# KITITAS COUNTY

### MEMORANDUM

SUBJECT: Mildon Short Plat

MILDON SHORT PLAT
 PART OF SECTION 12, T. 17 N., R. 17 E., W.M.
 KITTITAS COUNTY, WASHINGTON

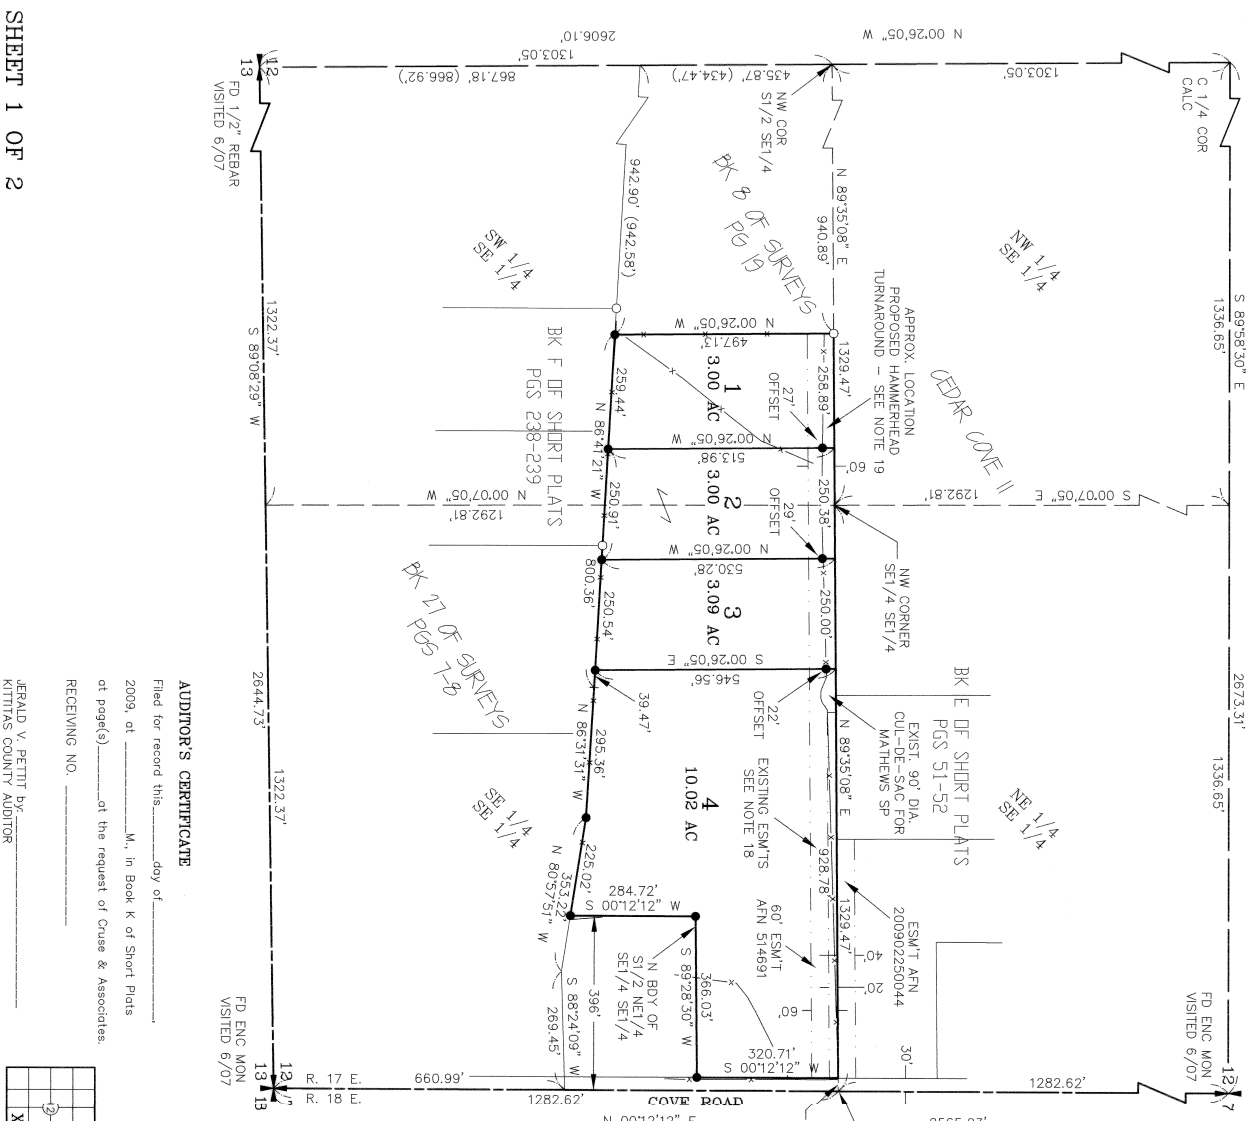
1. Legal Description: The legal description, as described on the preliminary short plat blue-line does not match the legal description, provided in the subdivision guarantee. The last paragraph of the legal description begins with "And except that portion of the south half of the northeast quarter..." The legal description, provided in the subdivision guarantee states:

"And except that portion of the south half of the southeast quarter..."

An accurate legal description shall be required on the face of the final plat.

3. Existing Access Easement: There appears to be a discrepancy with the location of the existing access easement, the property lines and the fence location, as shown on the face of the preliminary short plat. I have discussed the issue with the applicant and their representative and they have both indicated that they are aware of these issues and are working to resolve them, prior to final plat approval. This may involve re-establishing the access easement, further north, so it encompasses the existing road. All existing or proposed access easements shall comply with current Kittitas County Road Standards.
